HTE# BLES 2006-0010

EXISTING SEPTIC SYSTEM INSPECTION

NAME OF MOBILE HOME PARK OR S/D Johnson Farms I Lot 4

24x32 Det Garage

EXISTING CONDITIONS SURVEY FOR  
SHELTON MILES SATTERFIELD  
& DEBRA NEPHEW SATTERFIELD  
HARNETT COUNTY, NORTH CAROLINA

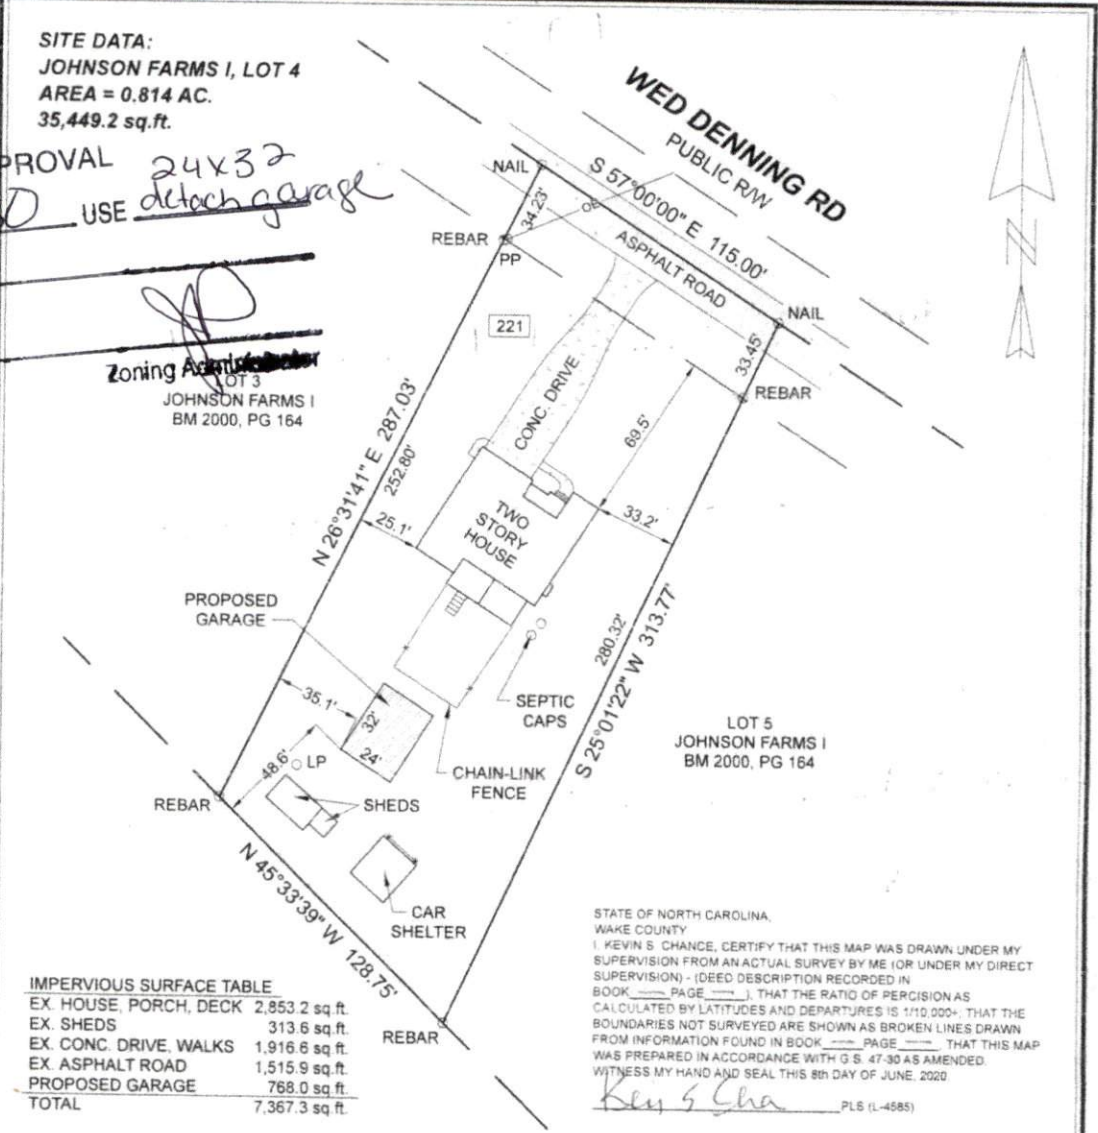
**BUILDING MUST BE 5' FROM ANY PART OF SEPTIC SYSTEM
DO NOT DRIVE OR PARK ON SEPTIC SYSTEM**
